CITY OF ALBUQUERQUE

**RE: Legacy 2 Multifamily
7800 Headline Blvd NE
Revised Conceptual Grading and Drainage Plan
Engineer's Stamp Date: 05/21/20
Hydrology File: D17D107**

Based upon the information provided in your submittal received 05/21/2020, the Revised Conceptual Grading & Drainage Plan is approved for action by the DRB on Site Plan for Building Permit.

GP01
GRADING PLAN

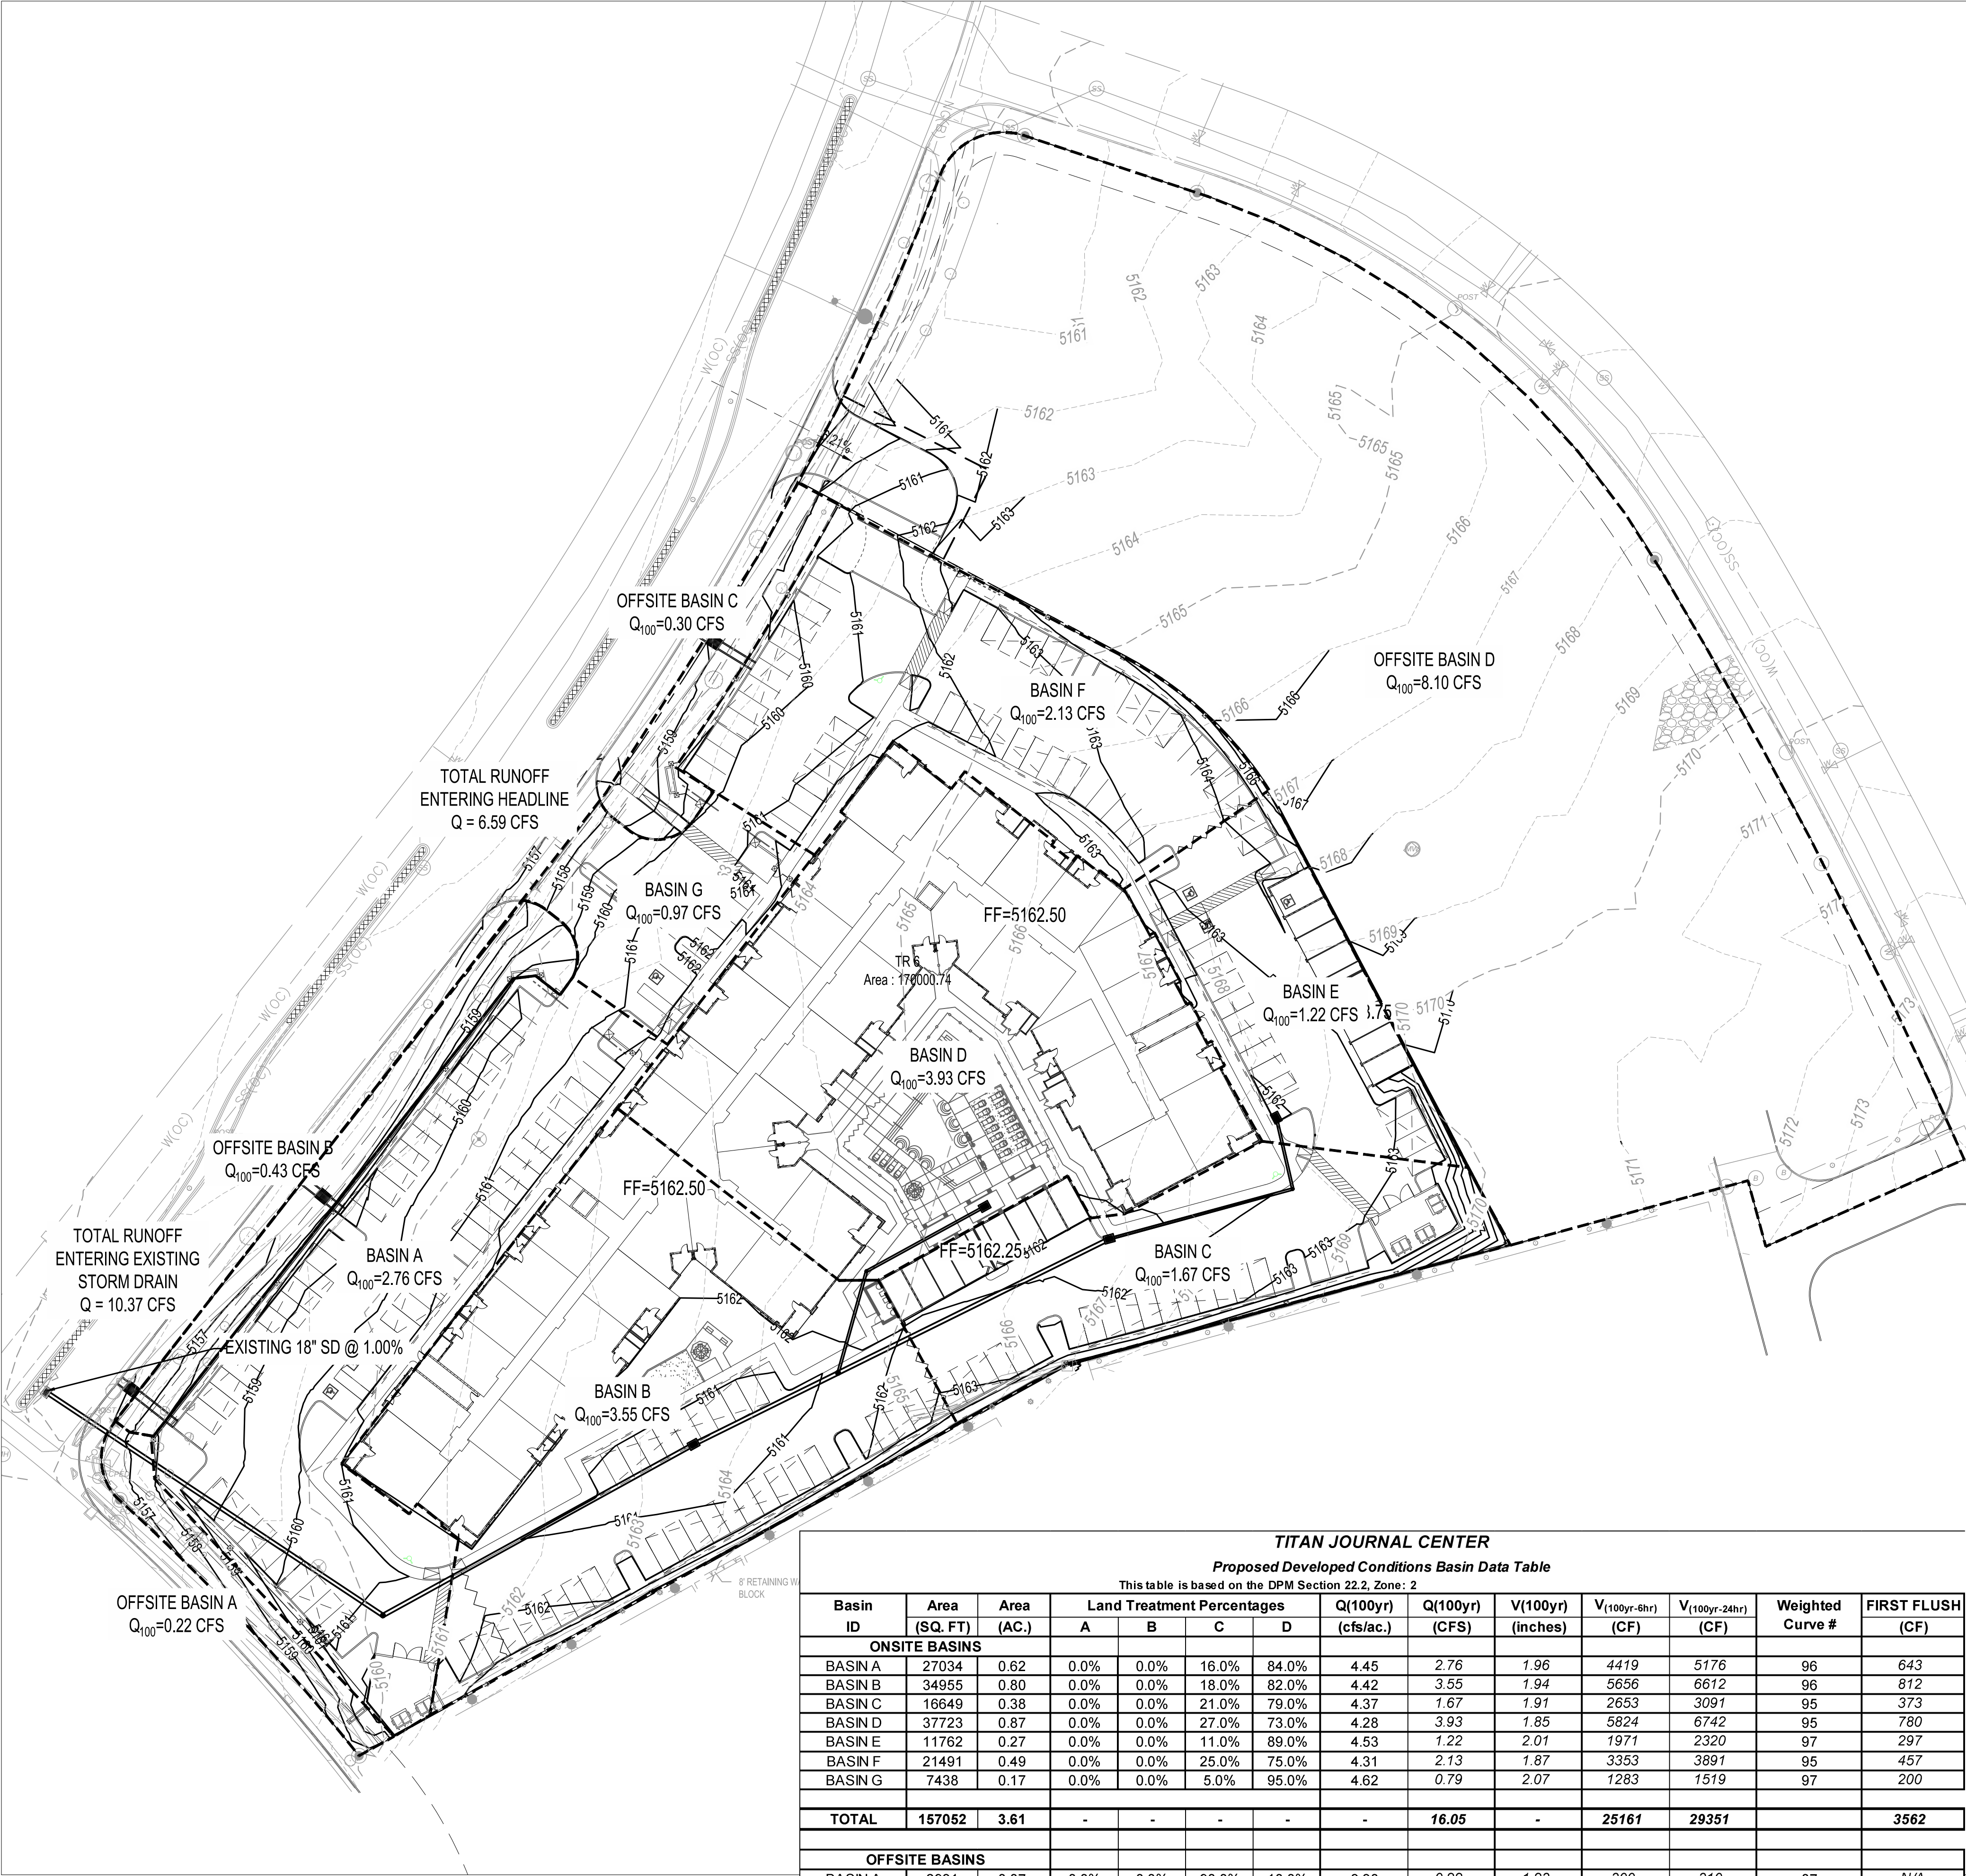
- In accordance with DPM Ch.22, section 5 part B, grading and wall construction near the property line may not endanger adjacent property or constrain its use. If the proposed retaining wall will create such an encroachment, written agreement from both landowners must be provided for such work. Written permission must include: signature of the property owner or owners representative, statement that undersigned is the owner or authorized representative, permission to construct the encroachment with a brief description of the encroachment.
